## **Development Facilitation Team (DFT) – Review Comments**

**Project No: PR-2022-007153**

### **Application For: SD-2023-00179-Preliminary/Final Plat (DHO)**

**Project Name:** Lands of Sawmill Bellamah Properties, LLC – 1904 Bellamah

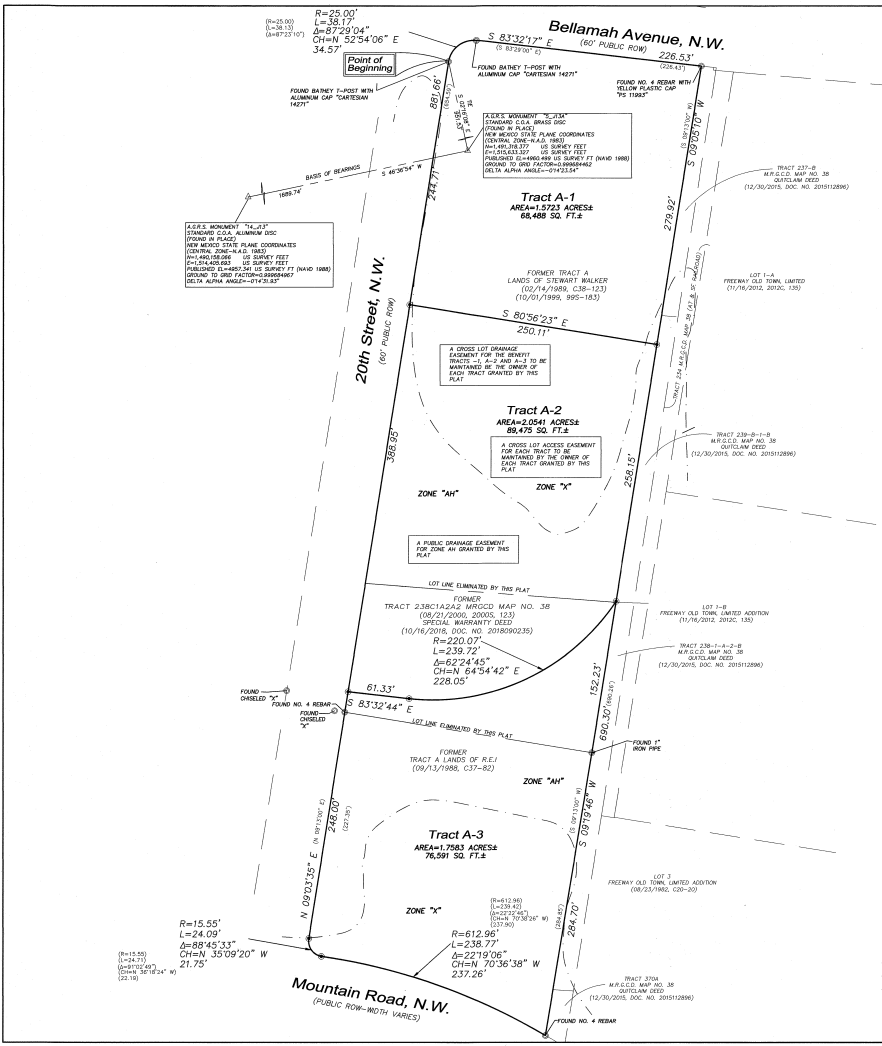
1. Please add the following note to the plat:
  - a. “Existing public water and/or sanitary sewer infrastructure may not be constructed or sized to adequately serve potential future development. Improvement or upsizing of existing public infrastructure may be required as a condition of future development approval.”
